A303 Sparkford to Ilchester Dualling  
My Registration Identity Number: 20015173

**A303 Sparkford to Ilchester Dualling**  
**Project TR010036**

**Summary of Written Submission**

**ENGINEERING SECTIONS
SLIP ROADS**

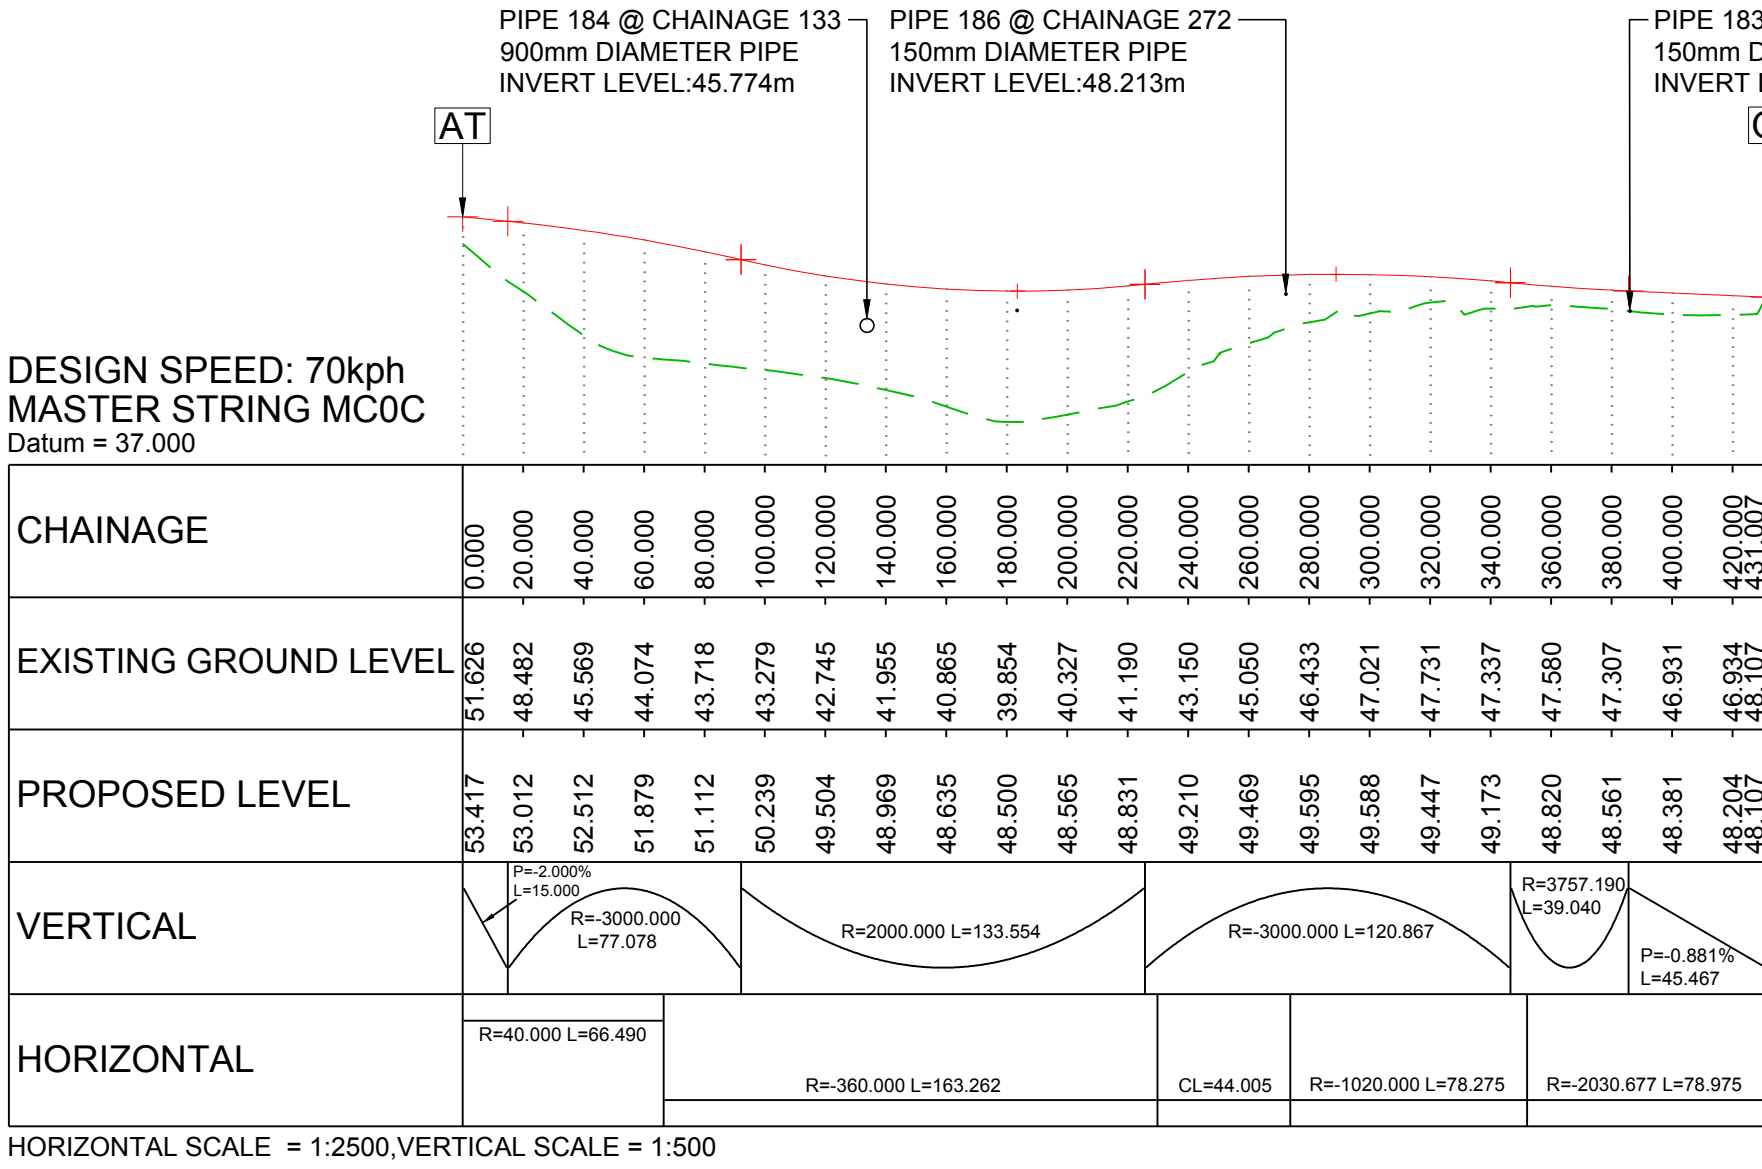
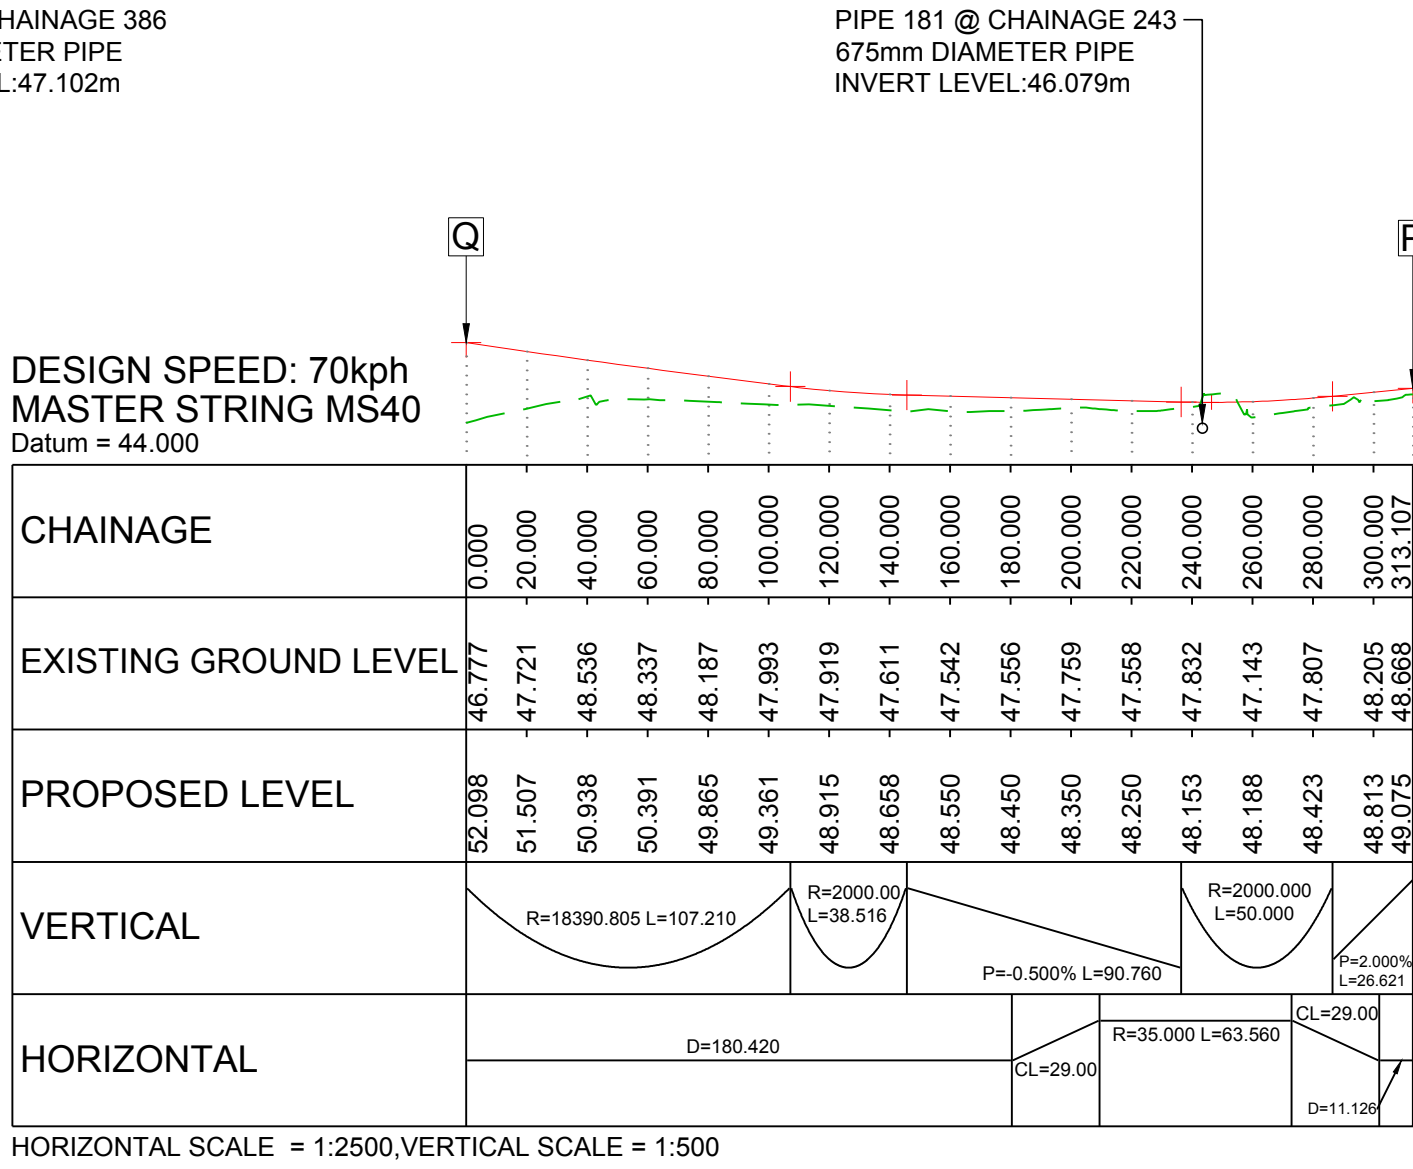
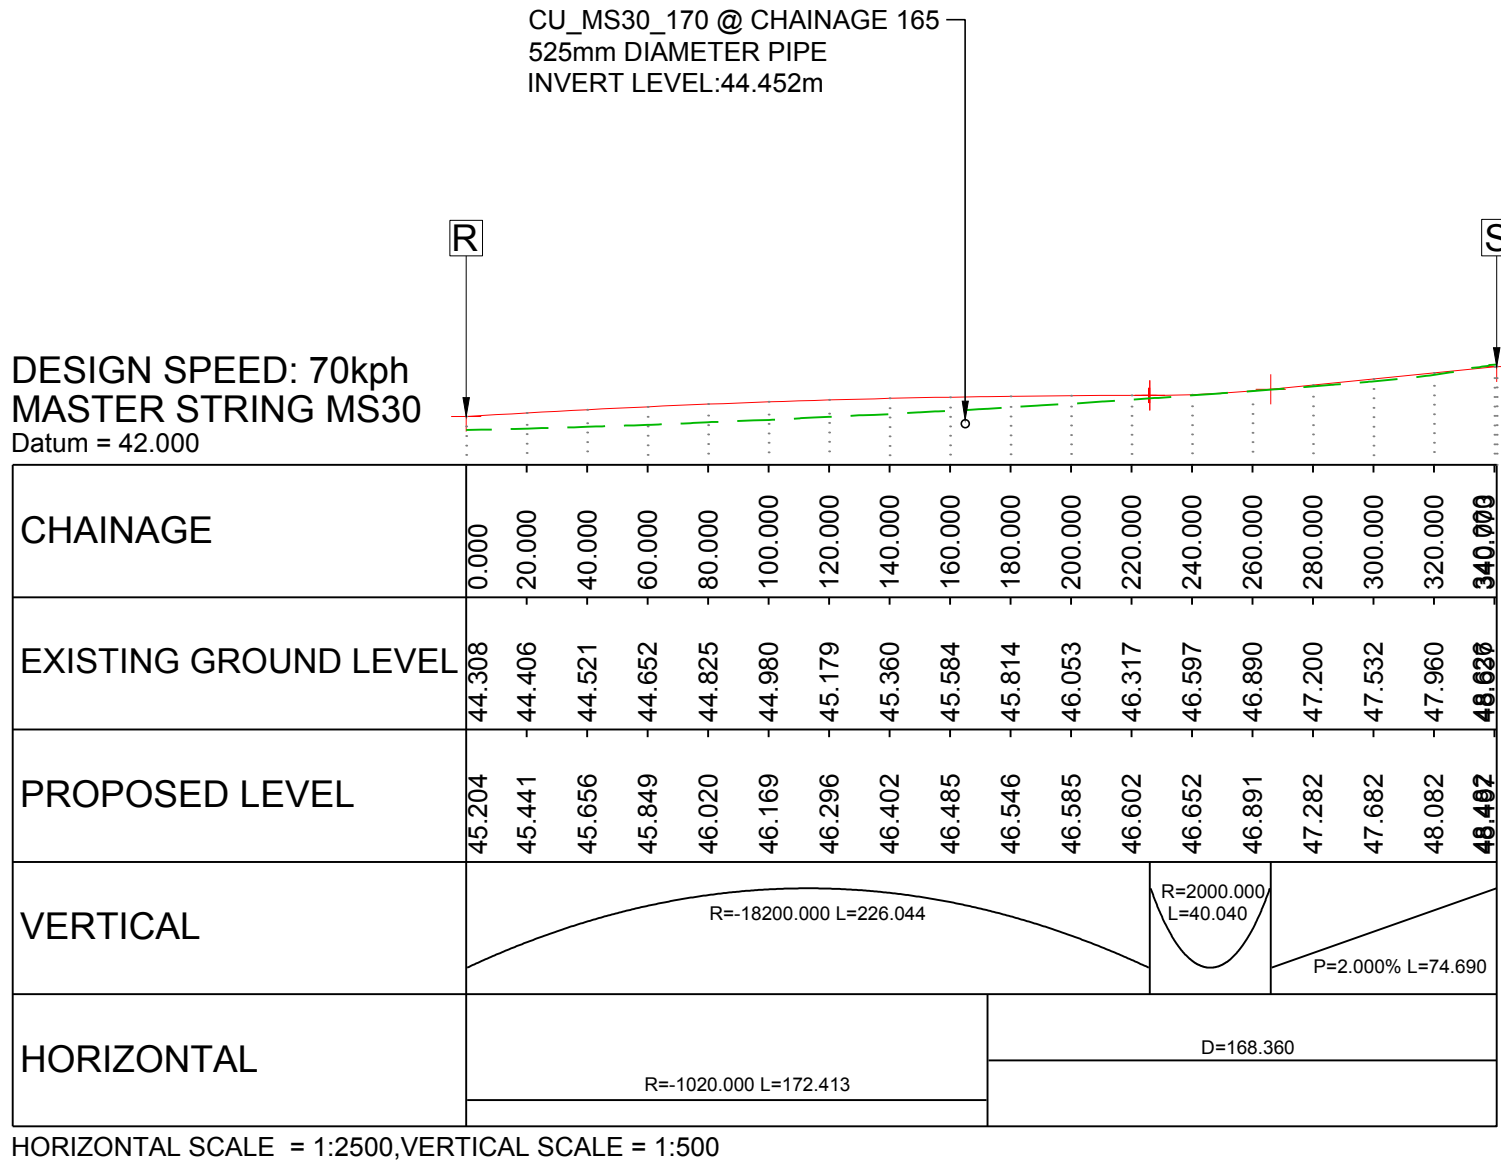
The Hazlegrove junction design is not user friendly, uses too much land and can be re-designed to achieve results that are more in keeping with existing highway designs, providing good safe access to Hazlegrove School and for users of the existing Services site and those entering the local road network.
